From: Harry Chalk
Sent: 14 May 2025 08:09
To: Planning.Responses
Subject: FW: AB/43/25/PD - Riverside House
Attachments: Existing Floorplans and Elevations (2).pdf; Proposed Floorplans (2).pdf; Sub Plan Action Sheet.docx

Subject: AB/43/25/PD - Riverside House

Following the previous planning appeal decision (APP/C3810/D/24/3339003) and notwithstanding The Local Planning Authority's sole reason for objection under AB/117/23/PD, the Planning Inspector found that there were additional components of the proposal that did not comply with the relevant criteria of Schedule 2, Part 1, Class AA. Notably, he Inspector identified that the single storey front bay, rear two-storey bay, and the single-storey front lean-to do not form part of the principal part of the dwellinghouse. As such, they concluded that these components prejudiced the schemes compliance with Class AA. I do note that the additional storeys above the garage have now been removed to address our prior concerns, but I also note that the additional two storeys continue to apply to the bay and lean-to features. As such, as the proposal stands, it remains non-compliant with the relevant sections of Class AA.

PROPOSED NORTH-WEST ELEVATION

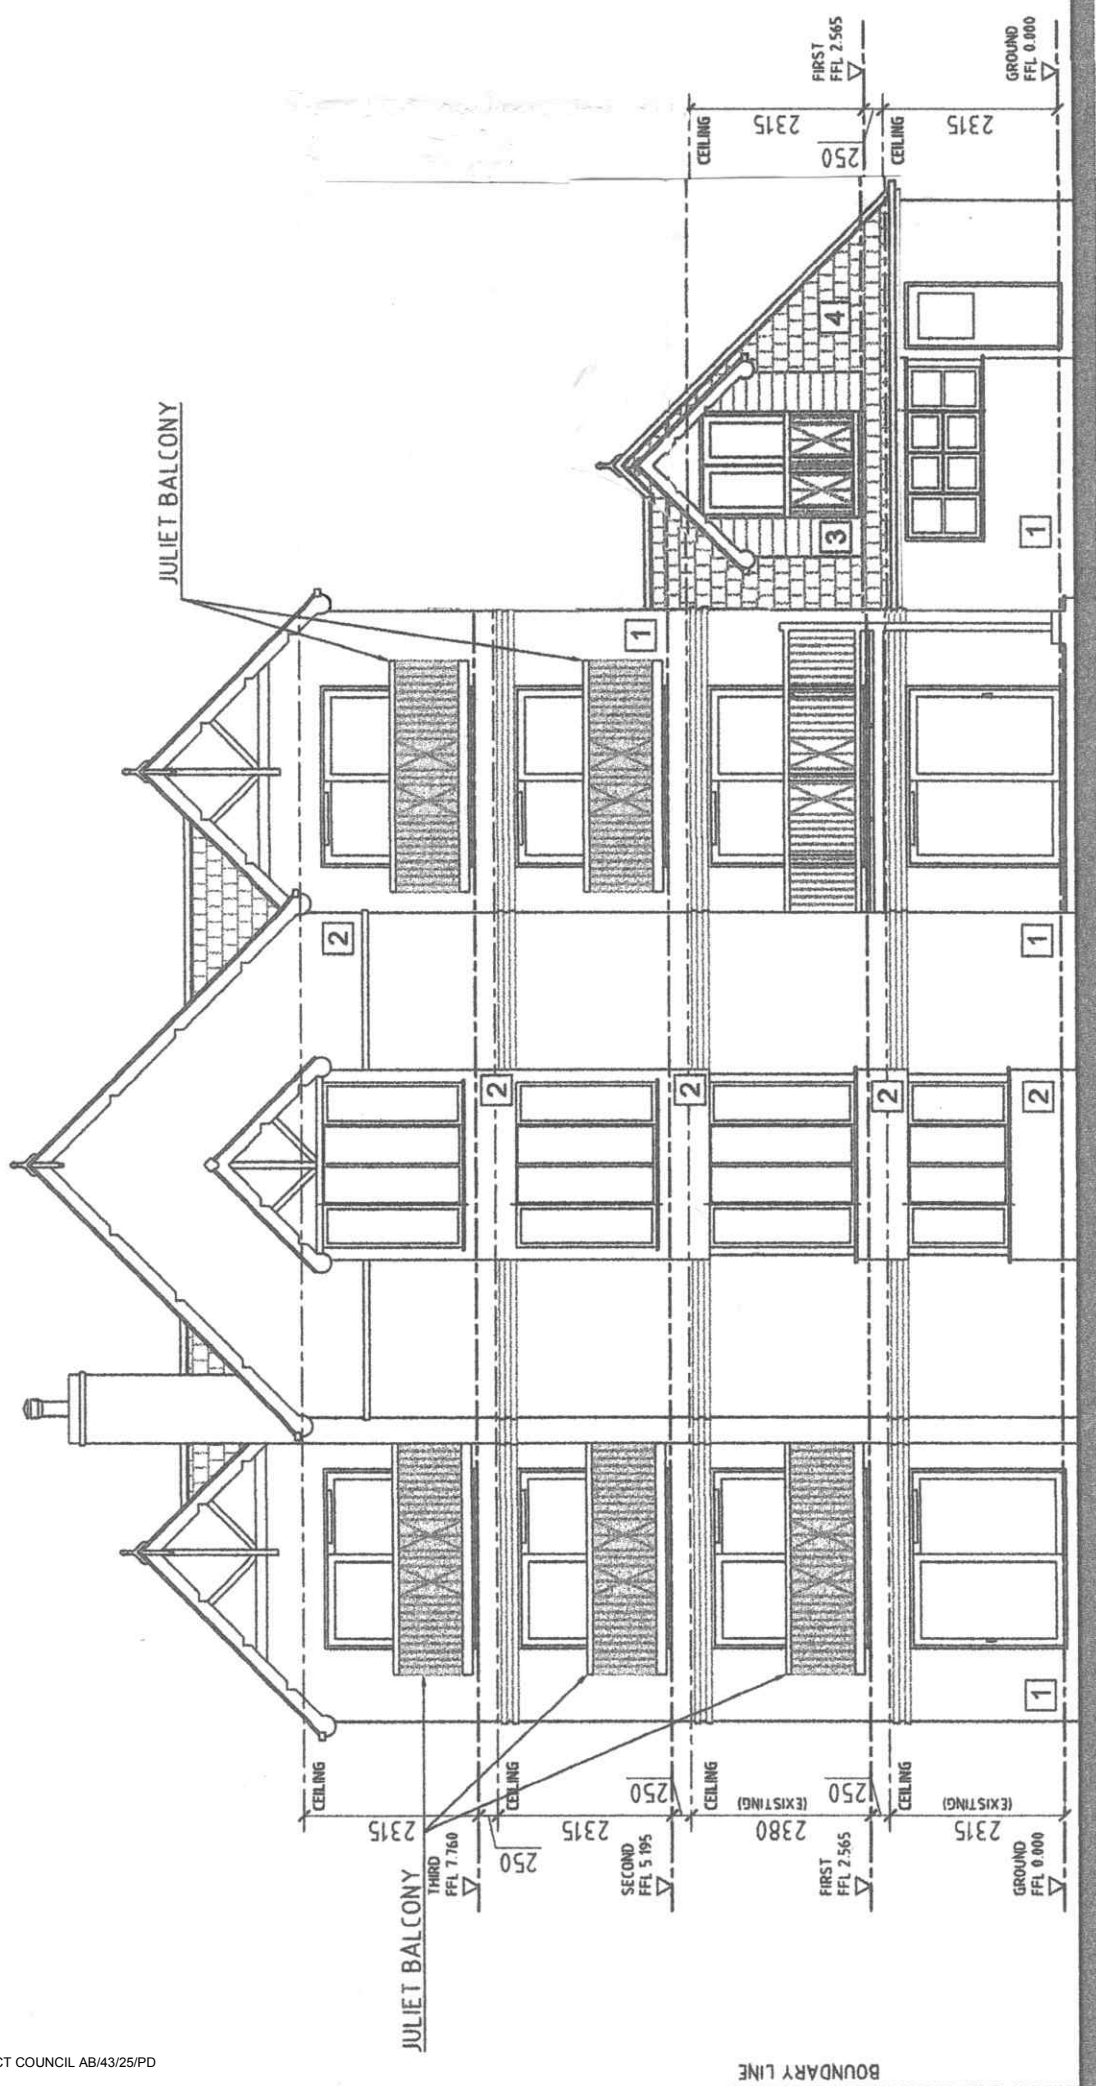
I would ask that the existing and proposed elevations be amended to remove the additional storeys from the bay and lean-to features identified by The Inspector, and to ensure the minor inaccuracies identified are addressed accordingly. Provided these amendments can be made by 09/05/25, we will have them uploaded and consider them further within our assessment of the application. In lieu of these amendments, it is clear that the proposal should be 'refused' in its current format in line with the prior conclusions of The Inspector.

EXISTING PLANS AND ELEVATIONS

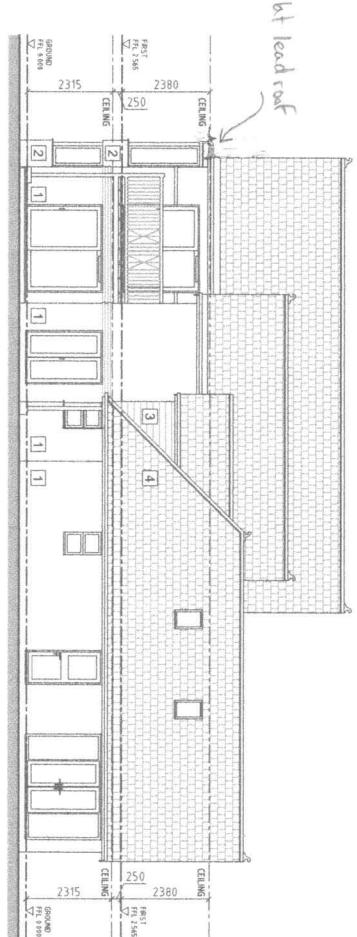
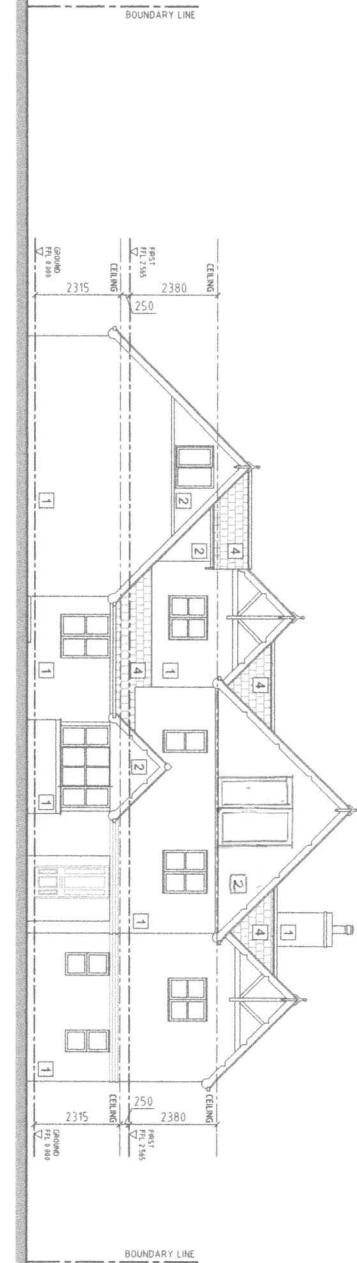
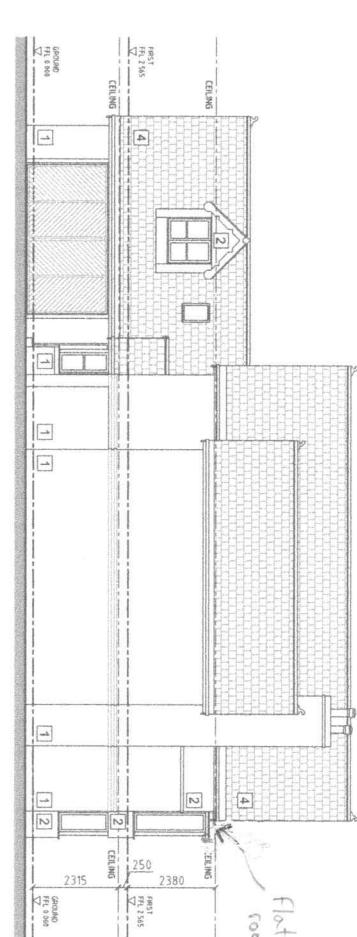
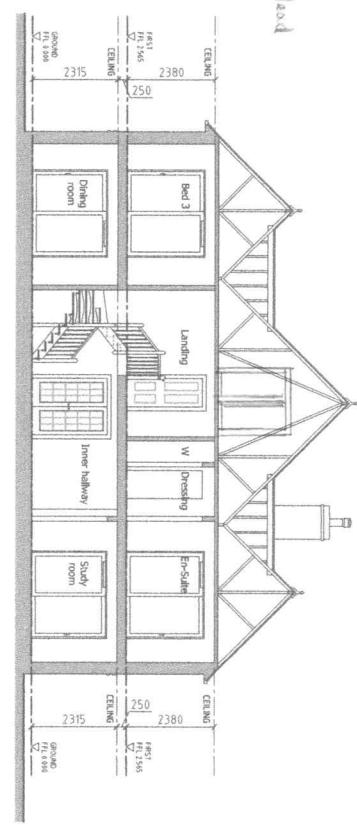
Having been double checking measurements on the provided plans, they do not appear to be scaling correctly. The scale and scale bar indicate the plans are at 1:100 however, when taking measurements against those annotated, 1:100 appears to be half the stated dimensions. In scaling the plans at 1:200, the plans and their given measurements all appear to line up. Could you confirm the correct scale for the plans (I expect it is 1:200)?

I also note that The Inspector found some inaccuracies in the existing elevations, these being the lack of a pitched roof to the rear tow-storey bay feature and the absence of the French doors to the front and rear central gables of the roof.

Please find plans with amended scale.
